TO: El Paso County Board of Commissioners
FROM: Planning & Community Development
DATE: 4/18/2023
RE: SKP-22-005, Jaynes Sketch Plan, N.E.S. Inc.

JAYNES PROPERTY SKETCH PLAN

LETTER OF INTENT MEMO

MARCH 2023

## SKETCH PLAN

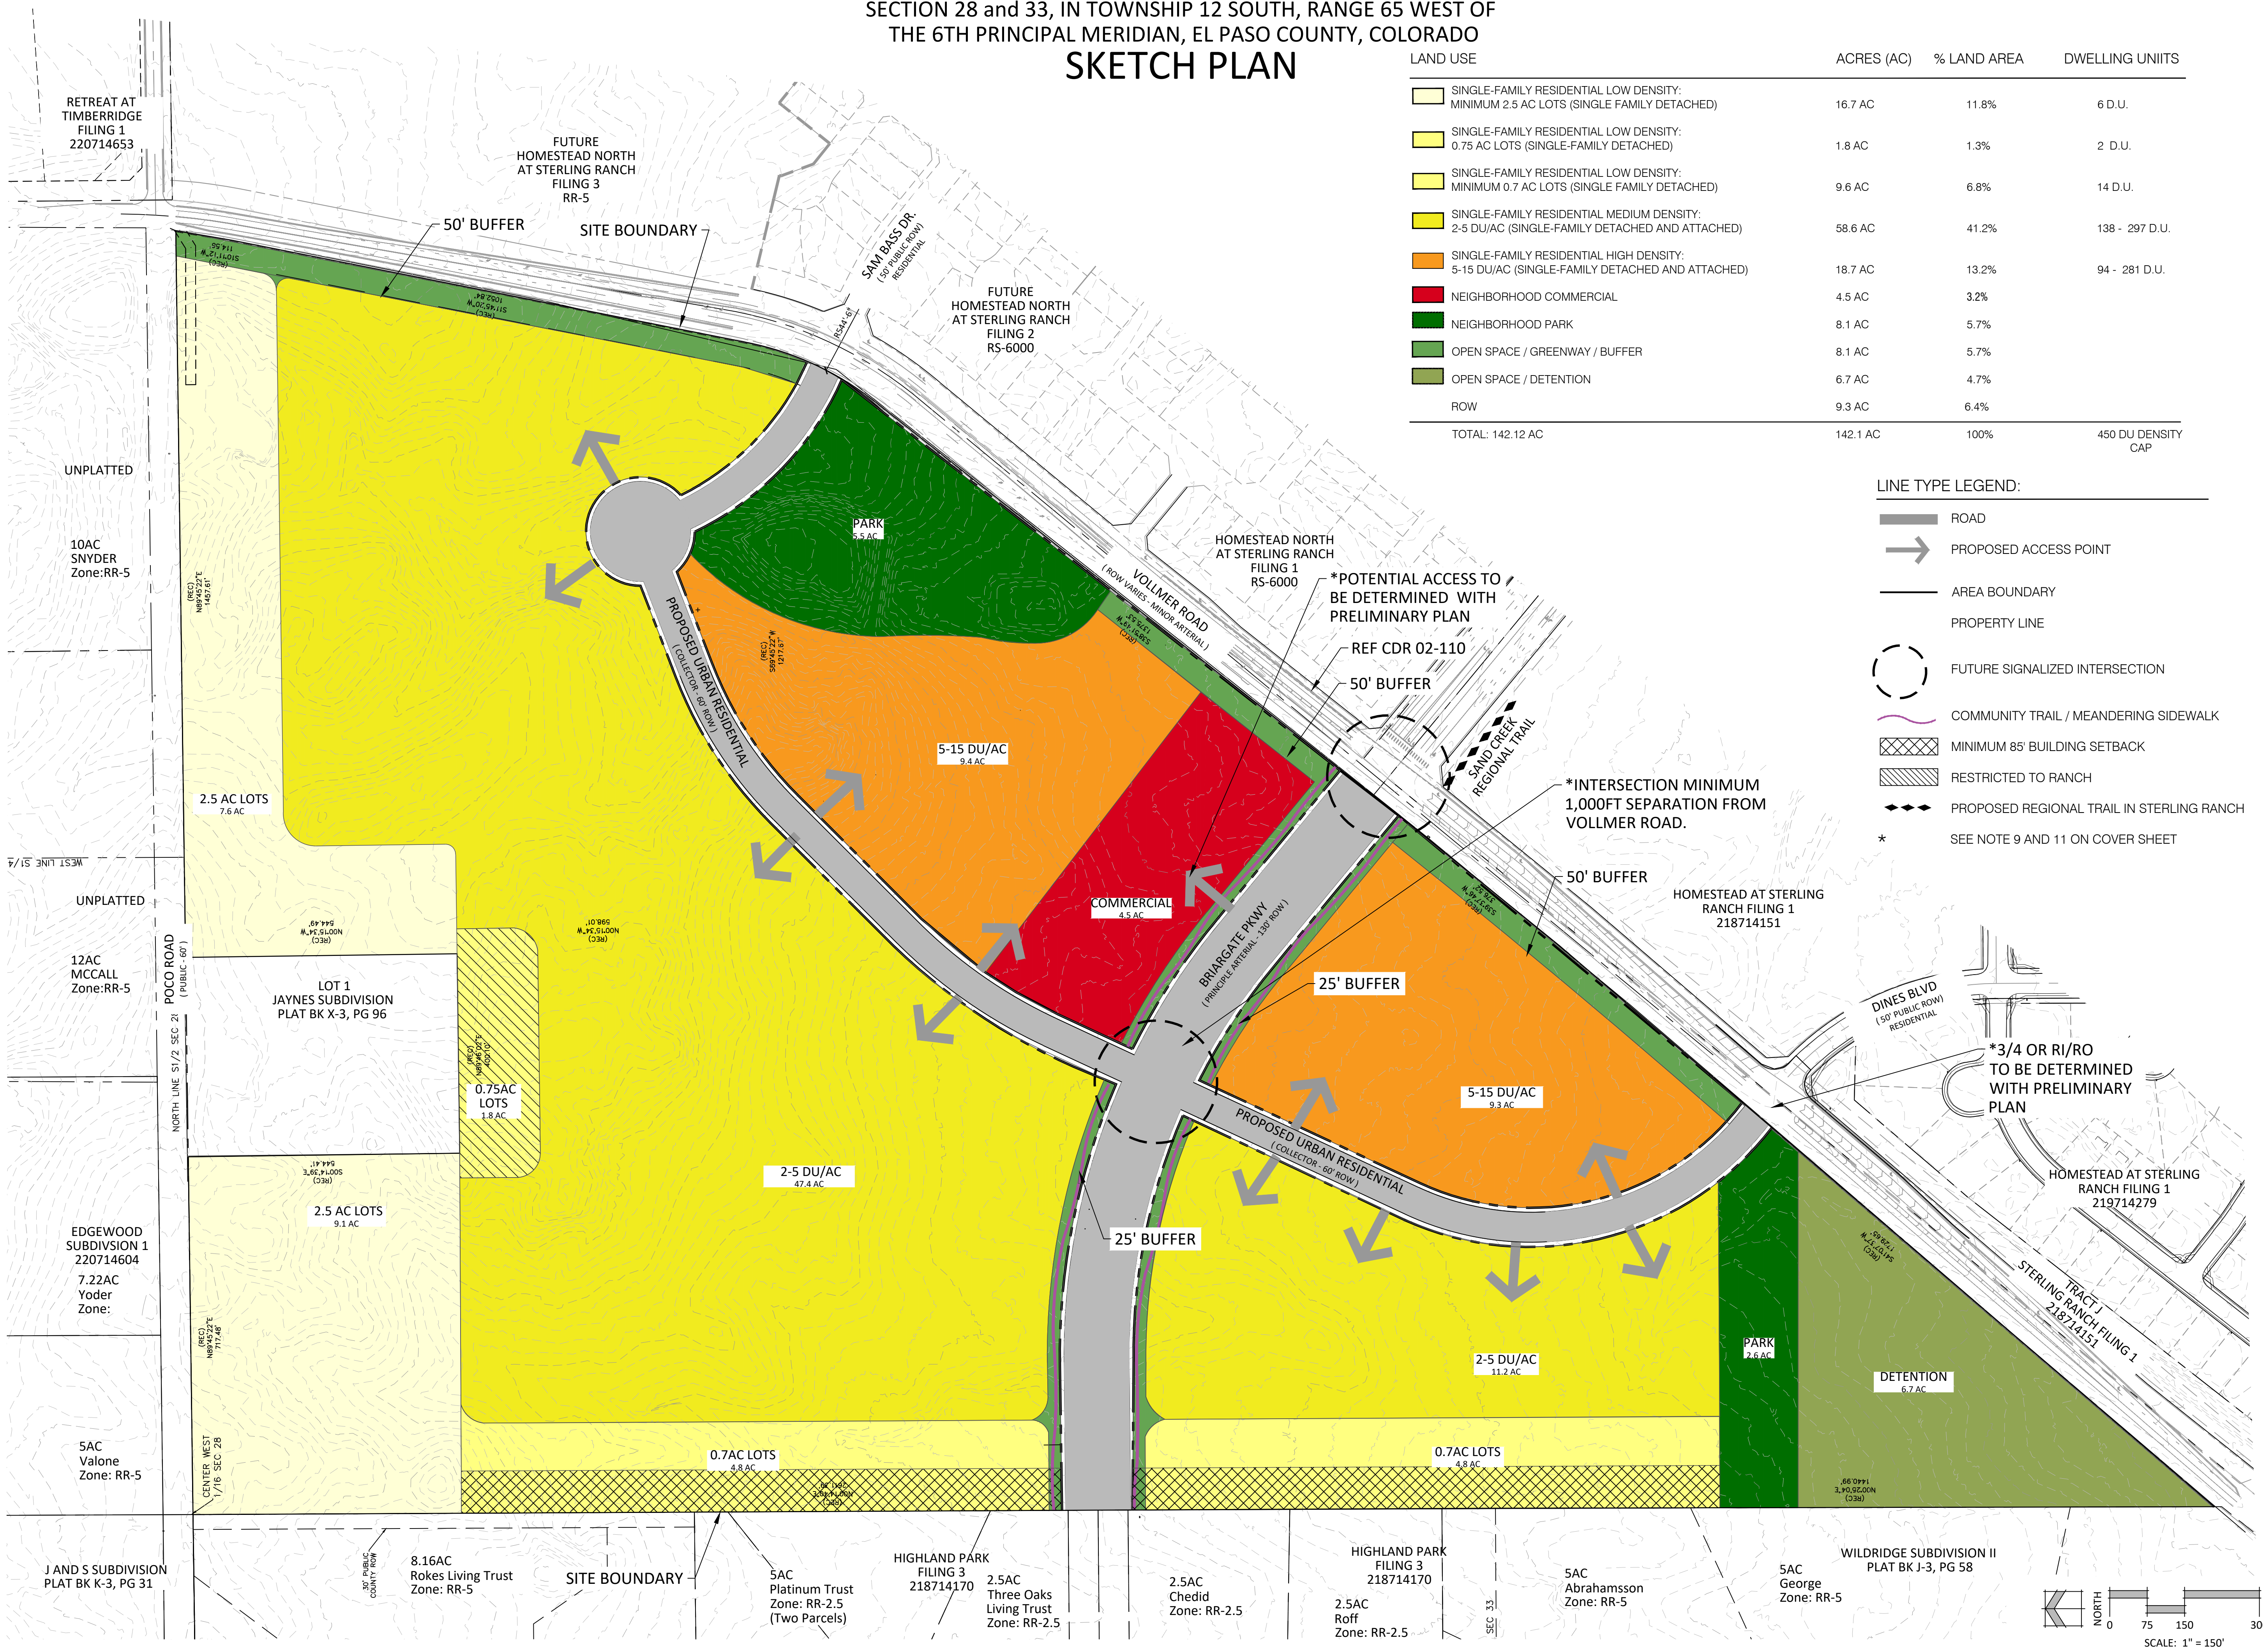
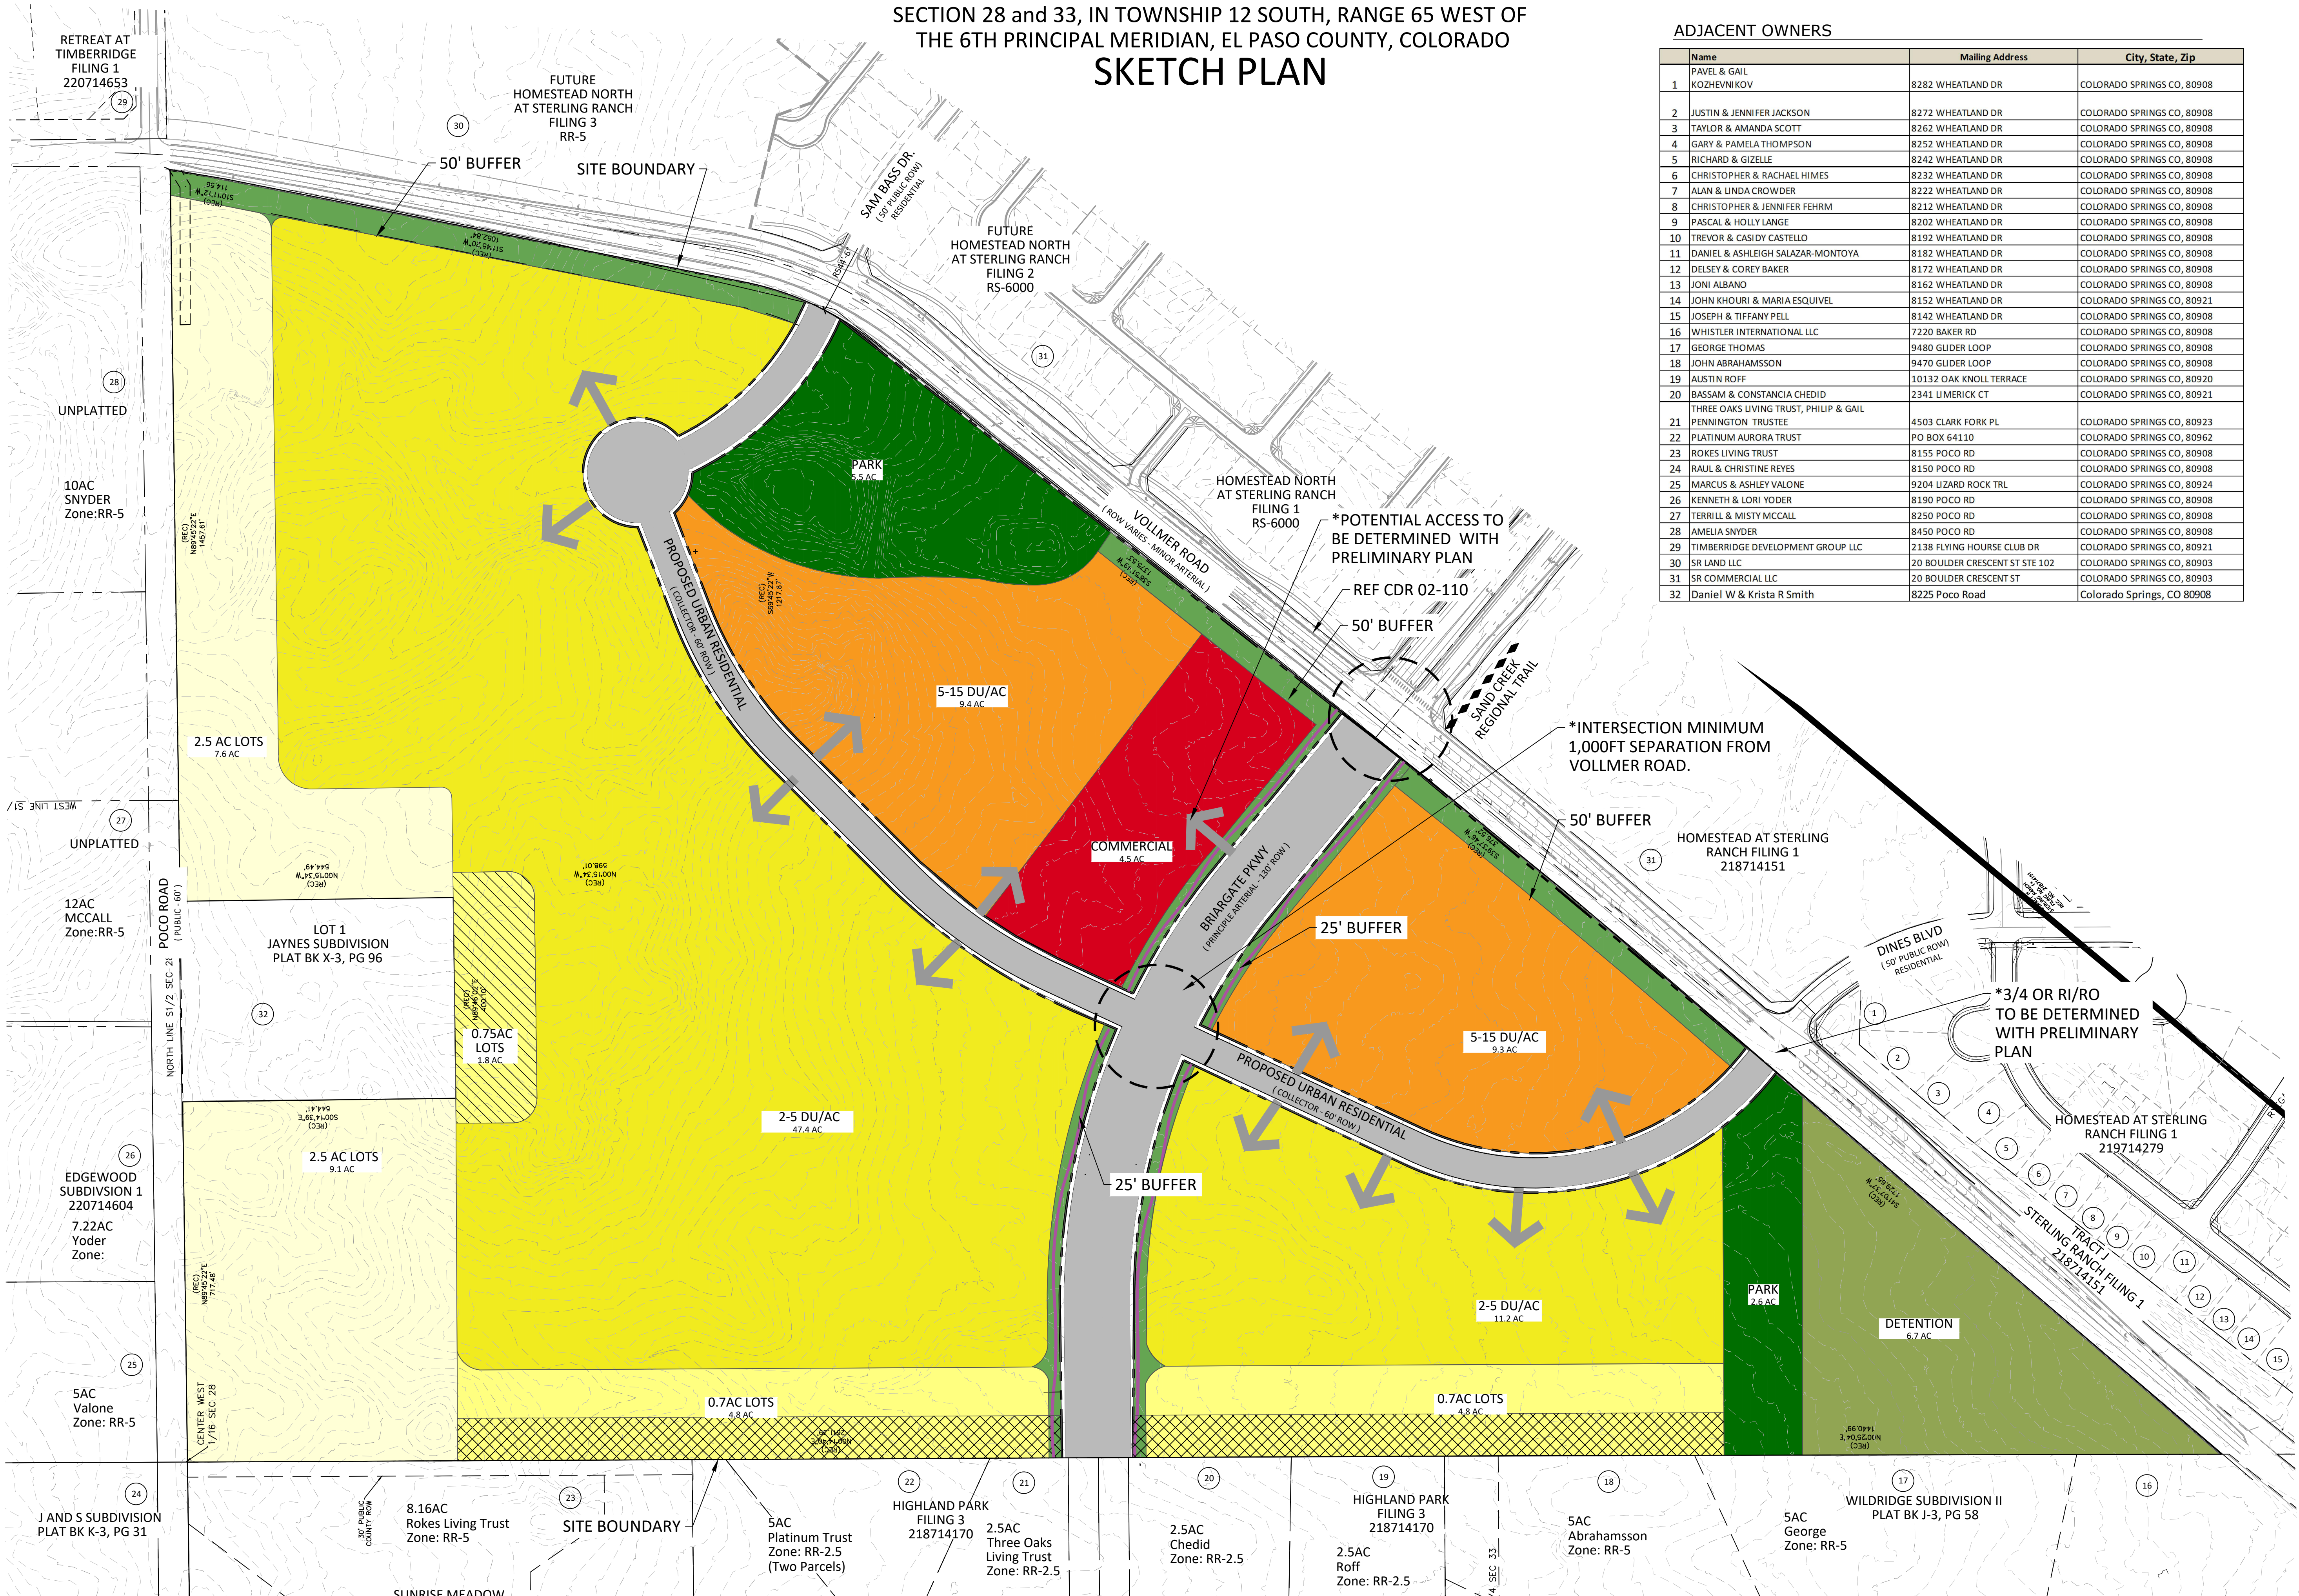
Jaynes Property Sketch Plan is amended to reflect comments received on 02/16/23 at the Planning Commission Hearing, relating to density transition from the existing rural residential lots to the north and west. Based on these comments, the following changes were made:

- Revision of 1AC lots along Poco Road to 2.5AC lots
- Removal of the 35' building setback along Poco
- Orientation of 2.5AC lots to match depth of the Smith Parcel
- Removal of the 50' buffer and 35' building setback around the Smith Lot
- Removal of the 50' buffer and trail along the west boundary
- Modification from 0.5AC lots along western boundary to 0.7AC lots with a 75' building setback by incorporating the 50' buffer into the lots.
- Increase in density interior to the site:
 - 5-12DU/AC has been changed to 5-15DU/AC

With these changes the max density of the sketch plan is below the 630 units analyzed with the traffic study. The density cap remains at 450 dwelling units. We believe that these changes will address the concerns related to density transitions while fulfilling the El Paso County Master Plan vision of Suburban Residential Development in the area.
